CITY OF PORTLAND

December 31, 2002

RE: 931 Congress Street – 065-D-014 – B-2 Business Zone

I am in receipt of your permit application to request a change of use from a retail appliance store to a beauty salon. Your plans are deficient. There are no dimensions shown on your floor plans. It is necessary to show dimensions on your floor plans. You have also not submitted a plot plan showing required parking. For public buildings located within a B-2 zone, it is necessary to show one (1) off-street parking space for each three hundred and thirty-four (334) square feet or major fraction thereof.

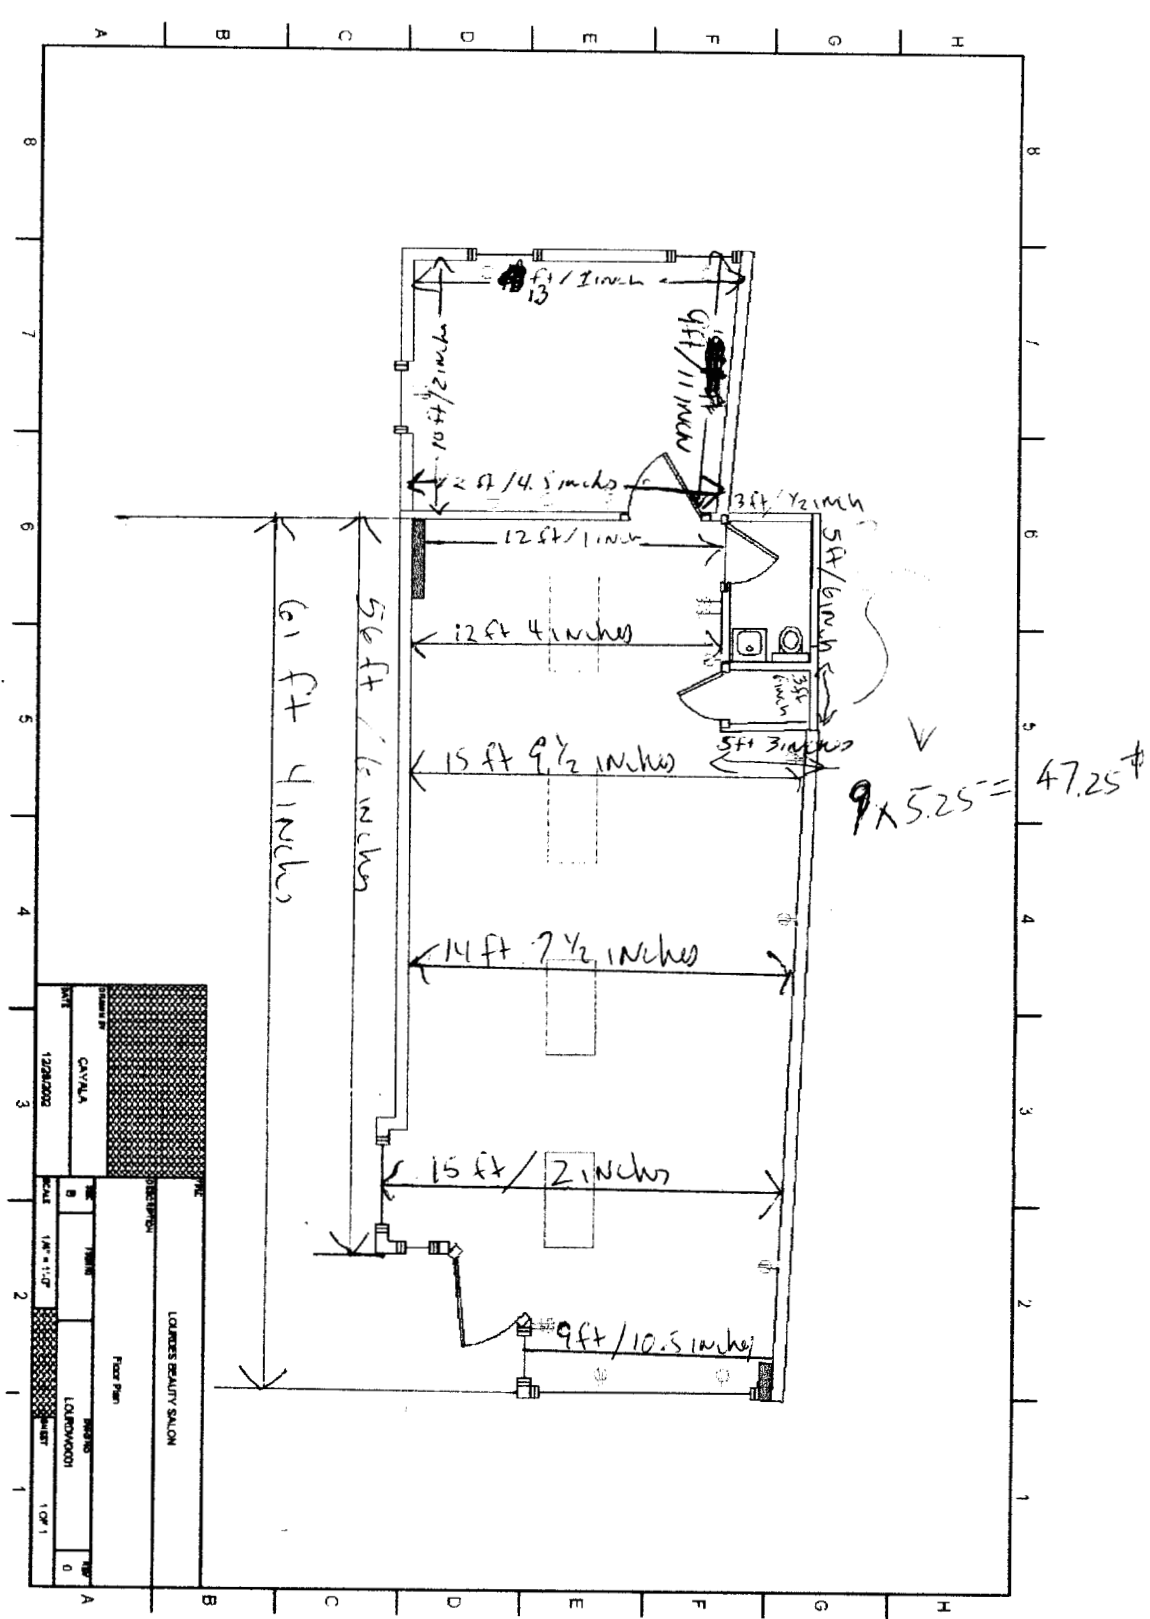
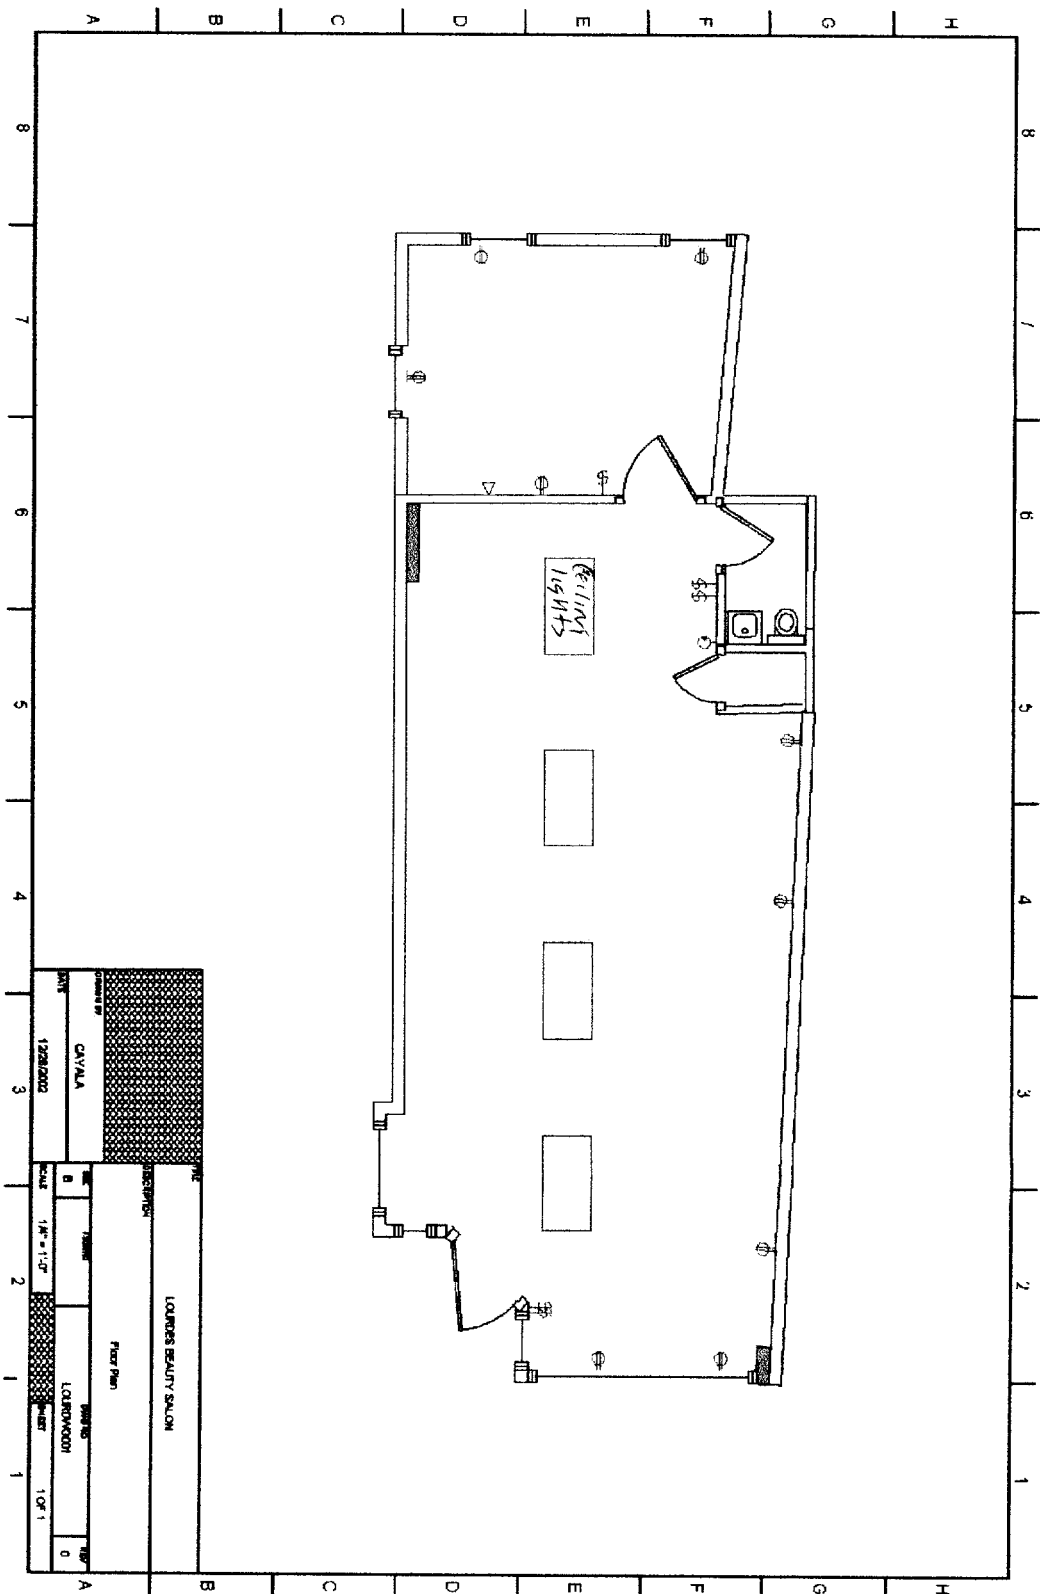
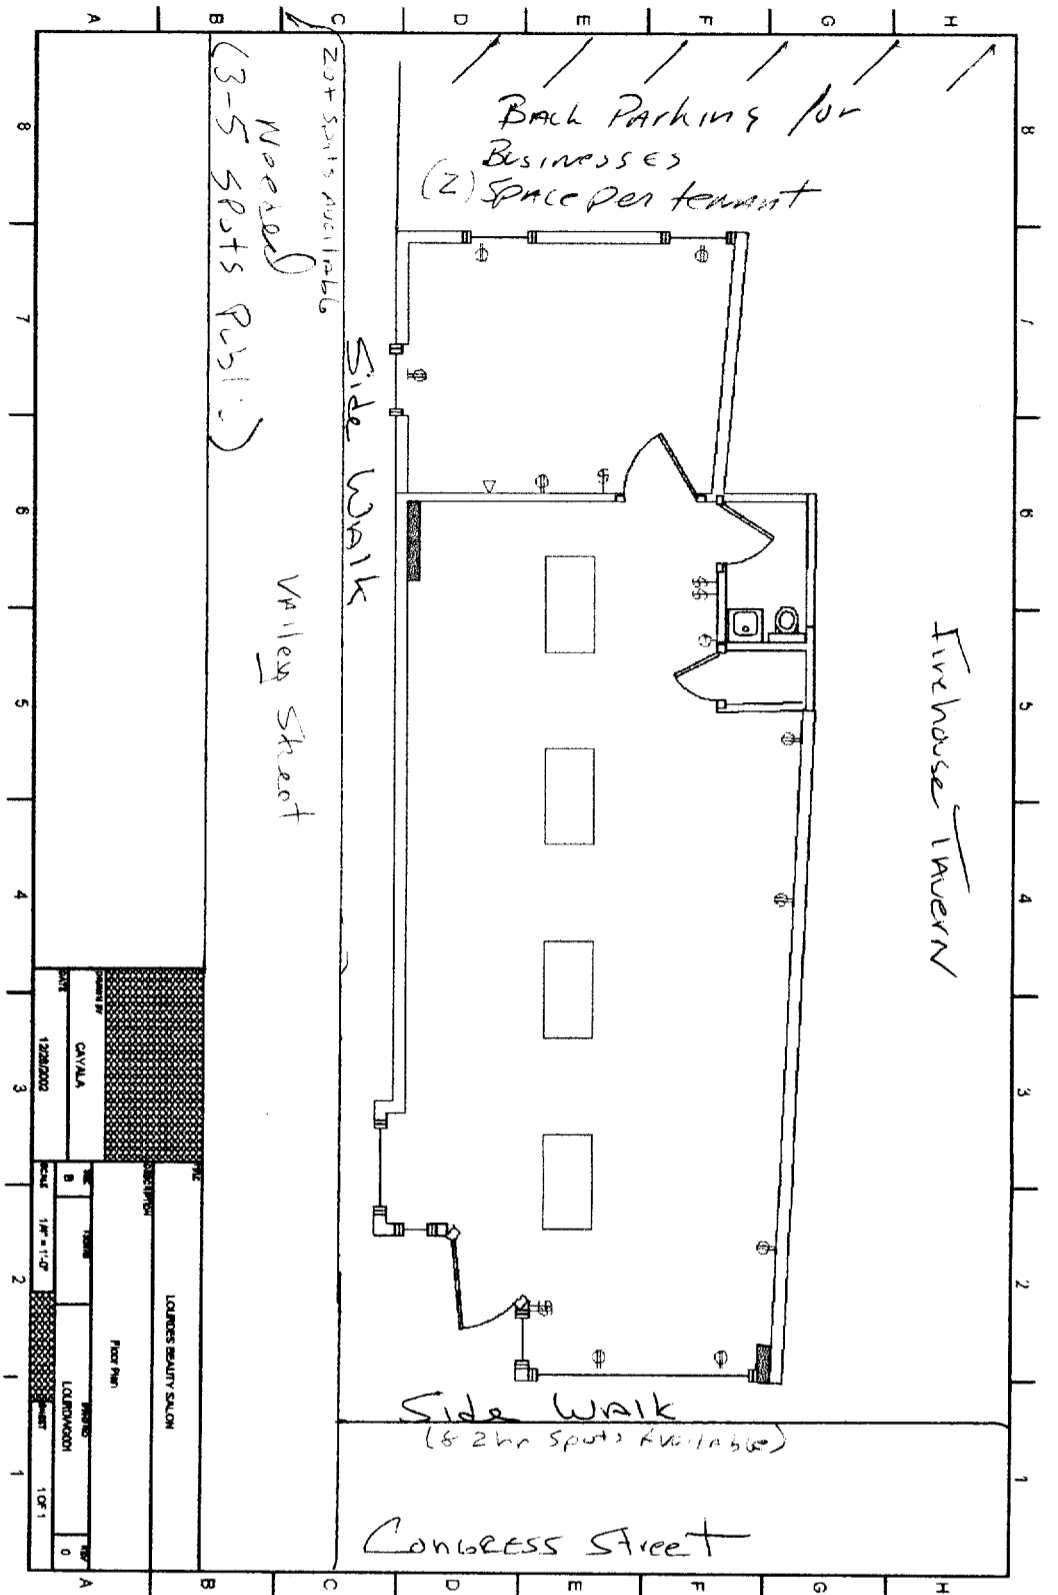
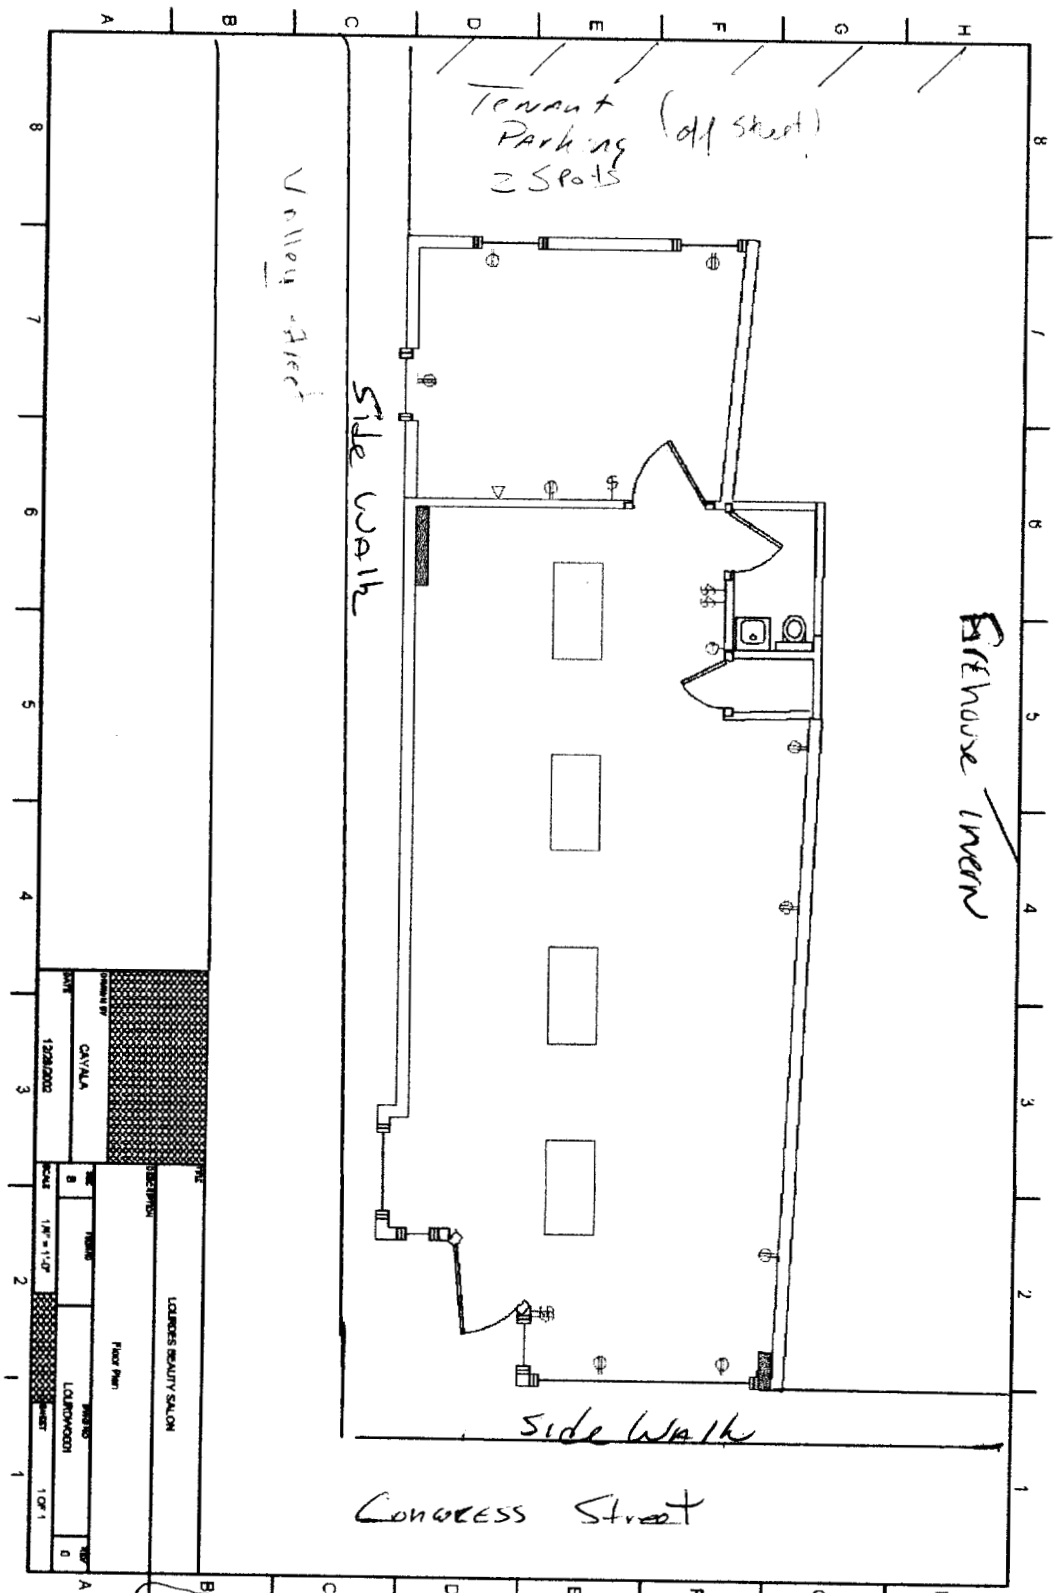
Note: 931 Congress St- 12/31/02 - see letter - no dimensions on the plans and no plot plan showing off-street parking **Ok to Issue:**

1/6/03 received reduced plans that are not to scale - I called Mr. Carpenter and told him that we need dimensions - for zoning & building & fire purposes. He will submit
 1/8/03 new plans brought in with dimensions which shows that 3 off-street parking spaces are needed only two are shown for each tenant.
 1/9/03 brought in a signed letter from the owner that allows three off-street parking spaces for this tenant

- 1) Separate permits shall be required for any new signage.
- 2) This permit is being approved on the basis of plans submitted. Any deviations shall require a separate approval before starting that work. This includes the revised plans that show the dimensions of the bldg and the letter from the owner of the bldg that allows three (3) off-street parking spaces for this tenant. Those three spaces shall be maintained throughout this tenancy.
